STATE OF NORTH CAROLINA
DEPARTMENT OF TRANSPORTATION

Subject: Request for Modification of the Phased Section 404 Individual Permit and Section 401 Individual Water Quality Certification, Neuse River Riparian Buffer Authorization for the construction of the Triangle Expressway Southeast Extension from NC-55 Bypass in Apex to I-40, Wake and Johnston Counties. TIP Nos. R-2721, R-2828, and R-2829. Debit \$570 from WBS 376731.TA2.

This letter is a request to modification on four sites of the R-2828 section of the Complete 540 project. Sites 32, 48, 49, and a new site (Site 91) are being modified.

MATCH LINE SEE SHEET 27
-L- STA. 857+00.00

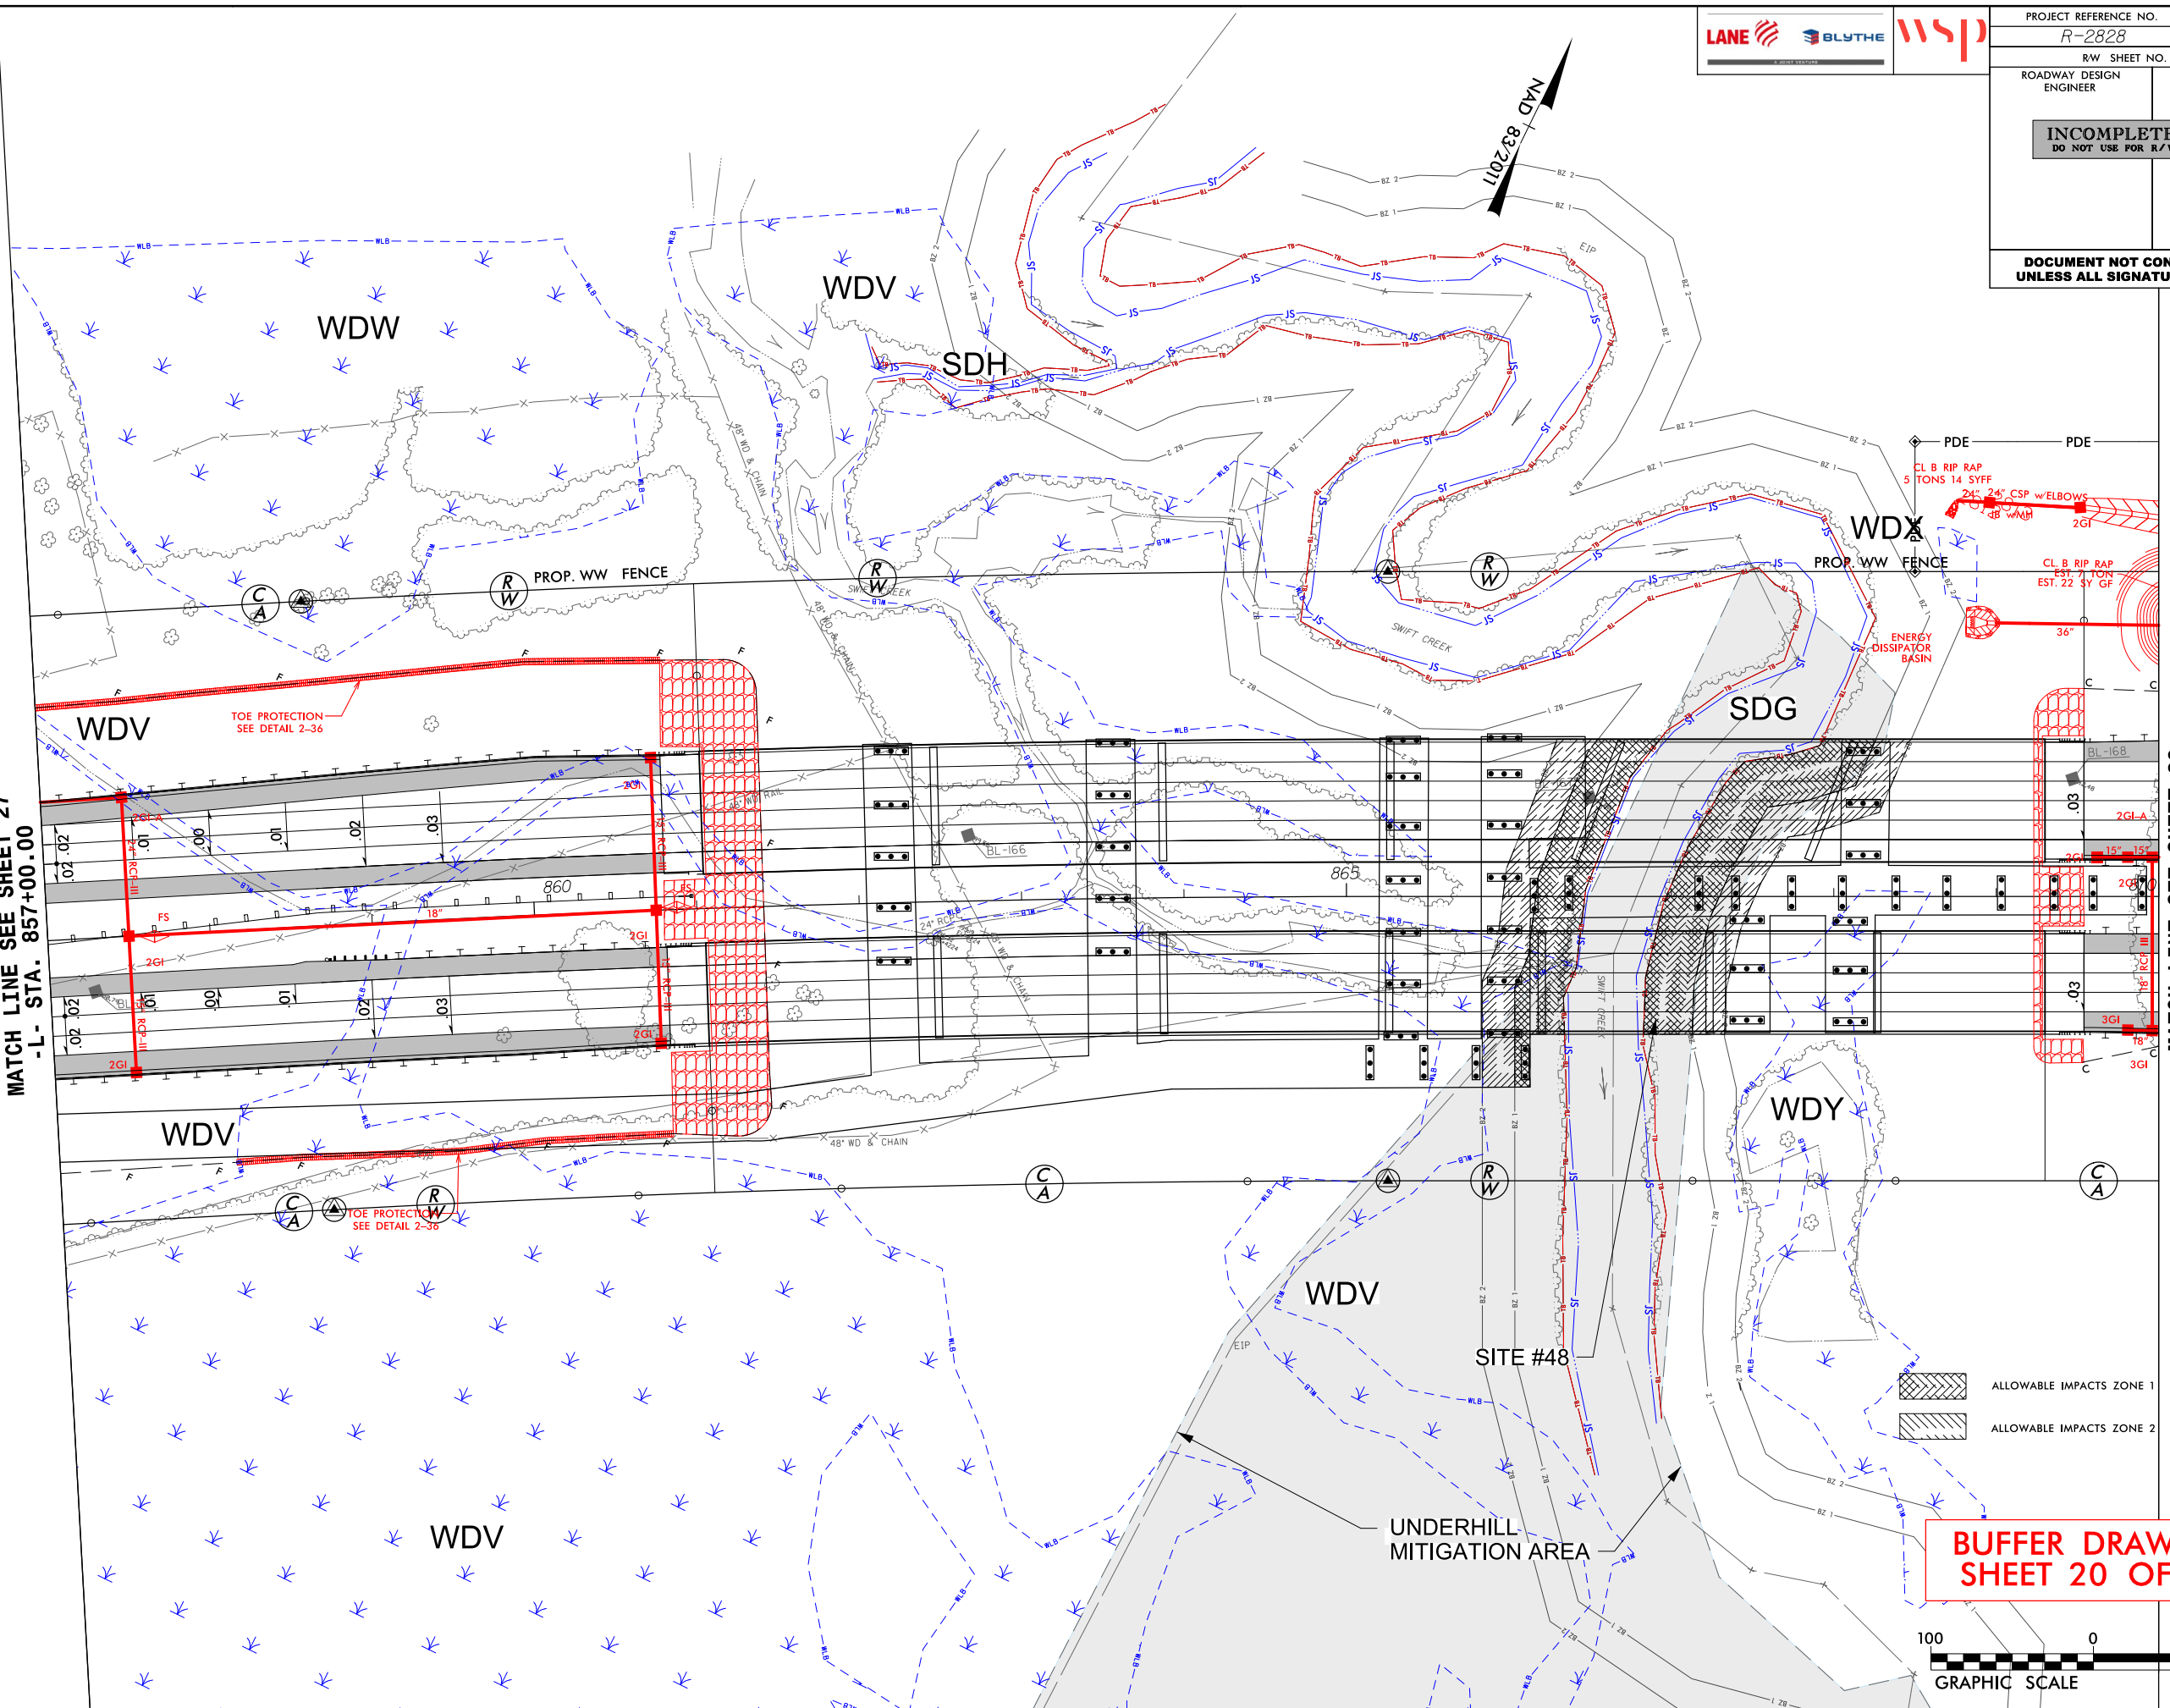
- Permit Site 48 (Buffer Drawing 20 of 42, Plan Sheet 28)
 - Alteration of work trestle configuration:
 - Increase of 2,160 square feet (Sq. Ft.) of Zone 1 Buffer Impacts
 - Increase of 1,168 Sq. Ft. of Zone 2 Buffer Impacts
- Permit Site 48 (Permit Drawing 105 and 106 of 171, Plan Sheet 28)
 - Alteration of work trestle configuration:
 - Increase of 0.014 acre of Hand Clearing Impacts
- Permit Site 49 (Permit Drawing 105 and 106 of 171, Plan Sheet 28)
 - Alteration of work trestle configuration:
 - Increase of 0.06 acre of Hand Clearing Impacts

PROJECT REFERENCE NO. R-2828	SHEET NO. 29
RW SHEET NO.	
ROADWAY DESIGN ENGINEER	HYDRAULICS ENGINEER
INCOMPLETE PLANS DO NOT USE FOR R/W ACQUISITION	
DOCUMENT NOT CONSIDERED FINAL UNLESS ALL SIGNATURES COMPLETED

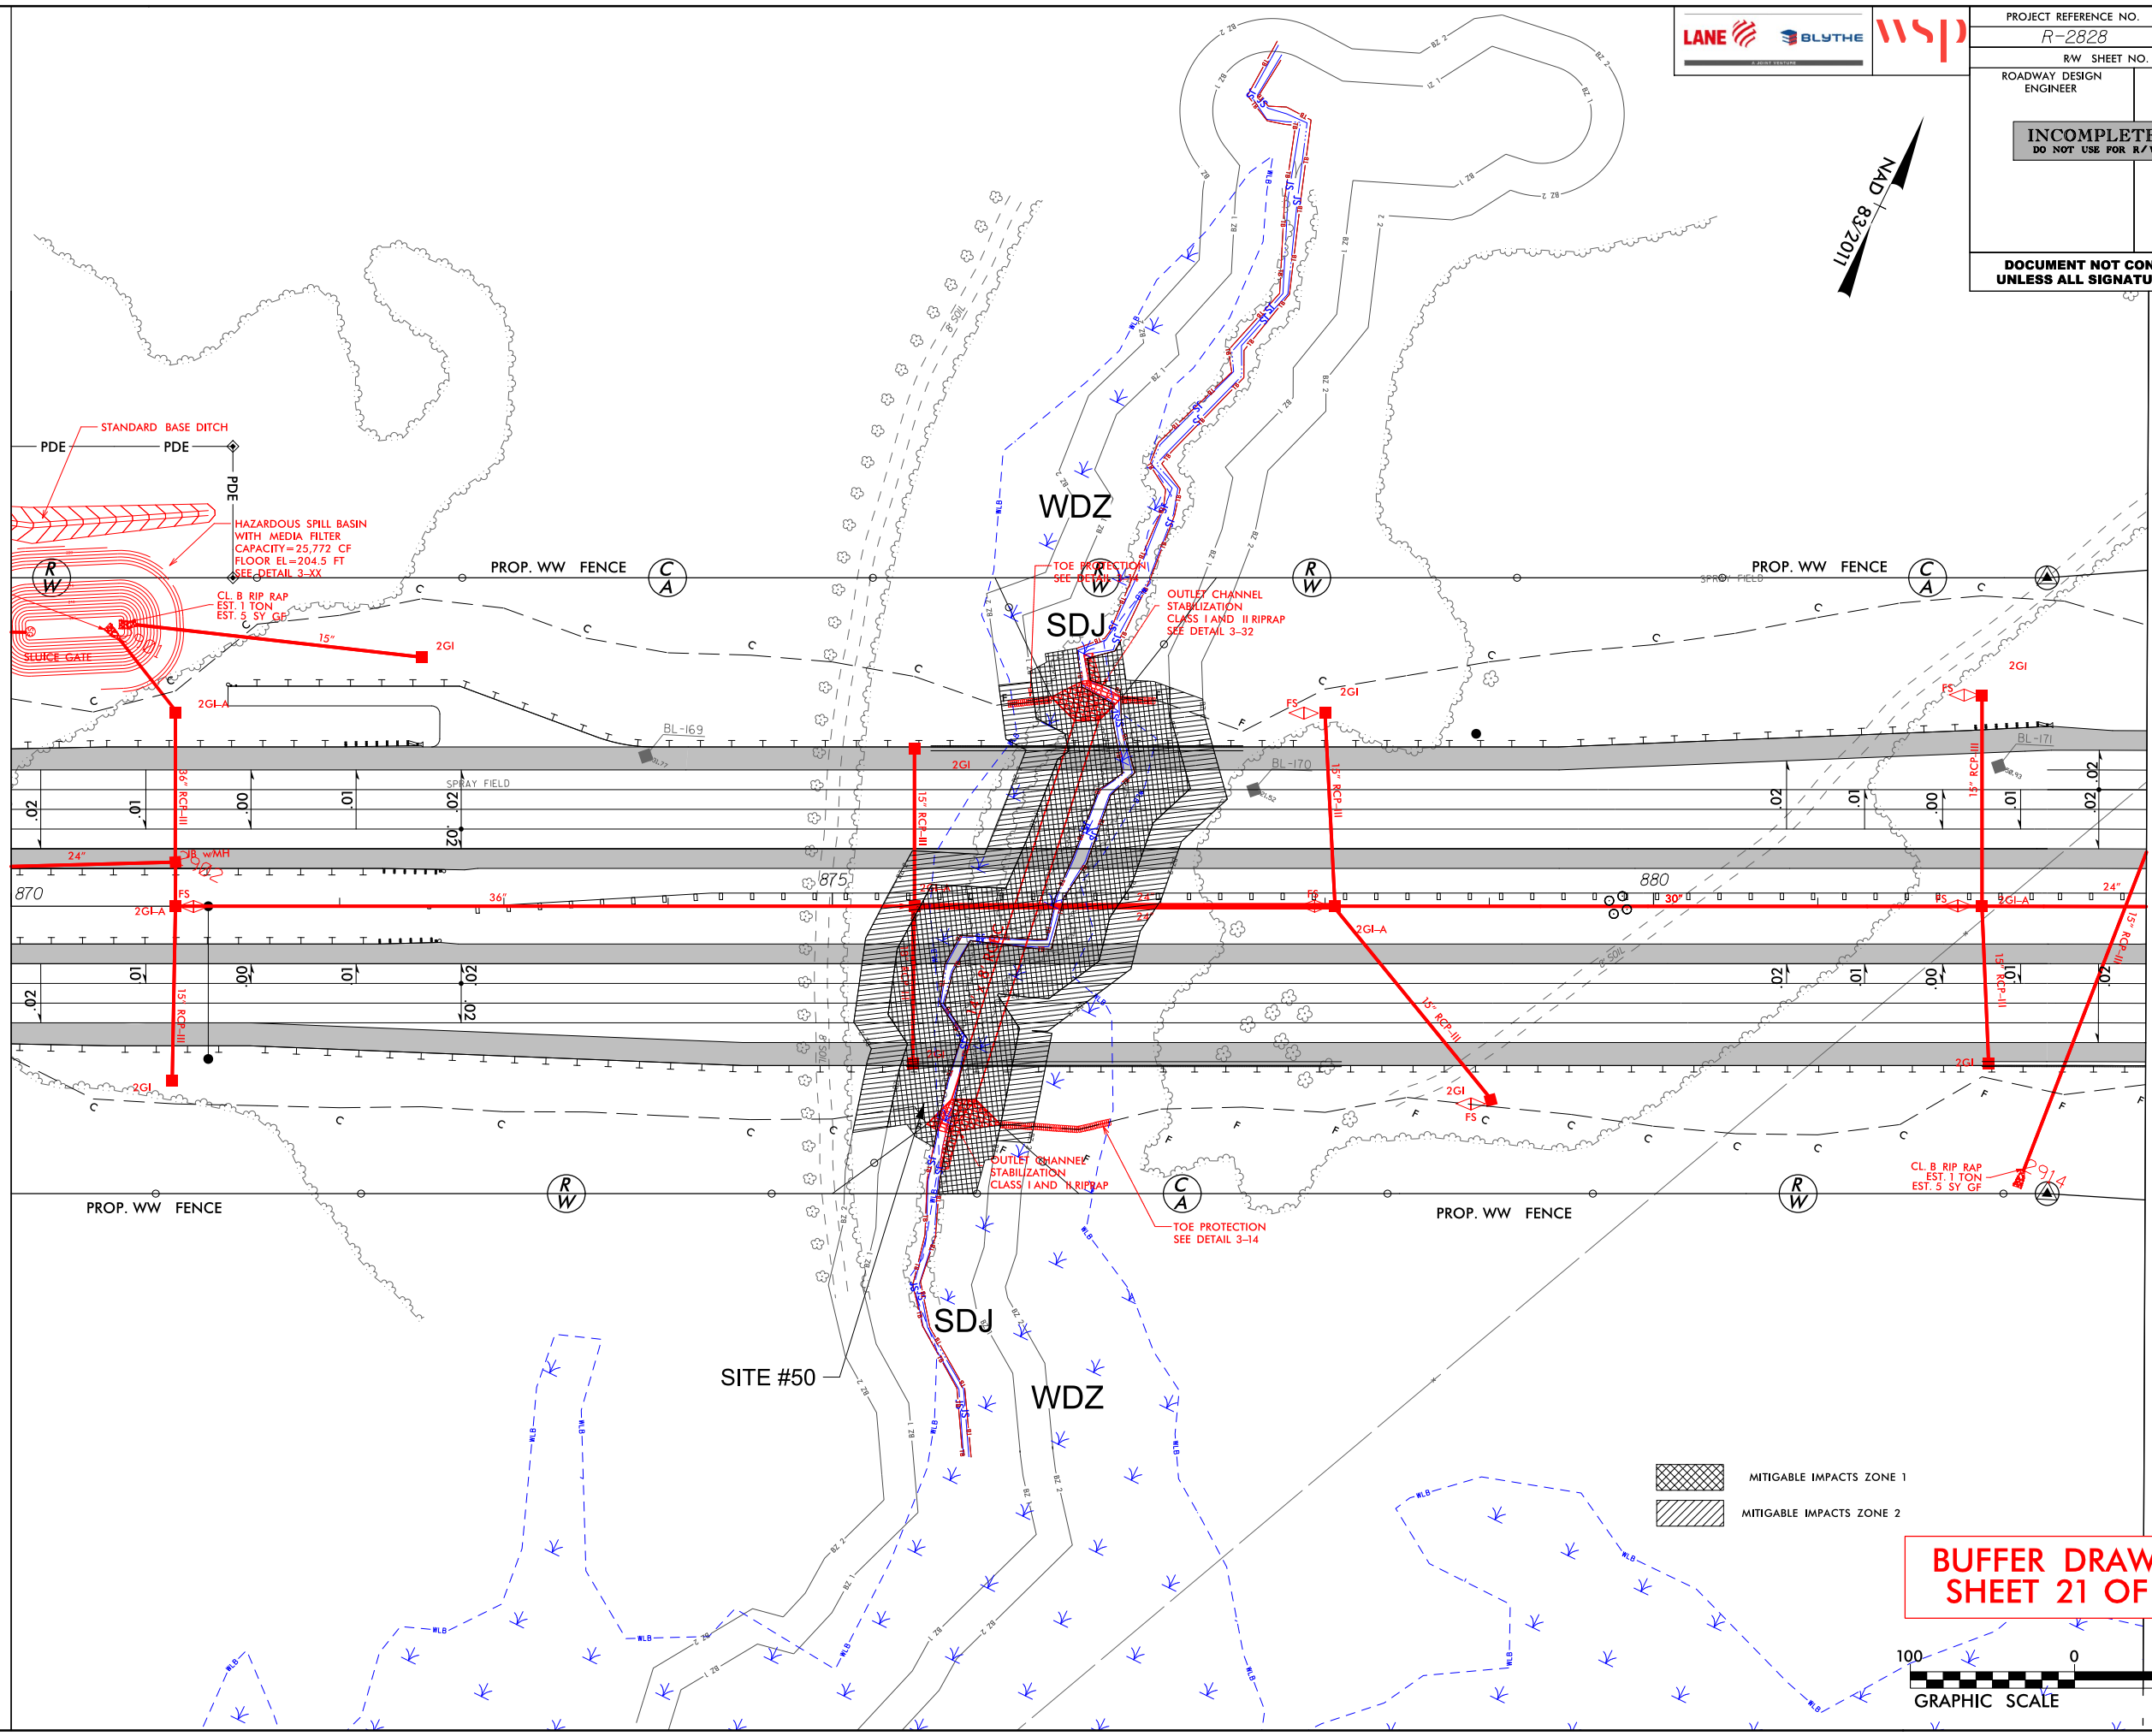
The new design removes the bend with a straight haul road which results in a safer delivery and erection of the bridge girders, a depiction of which is provided in Attachment B. The new haul road design is provided in revised Plan Sheet 29, but there is no change in jurisdictional impacts. All girder deliveries will be along this straightened portion of the trestle. This proposed design improves safety related to the delivery of other related bridge materials, that include formwork and reinforcing steel and removes any turning movements for concrete deliveries. This proposed design also eliminates permitted disturbance between the bridges east of Swift Creek.
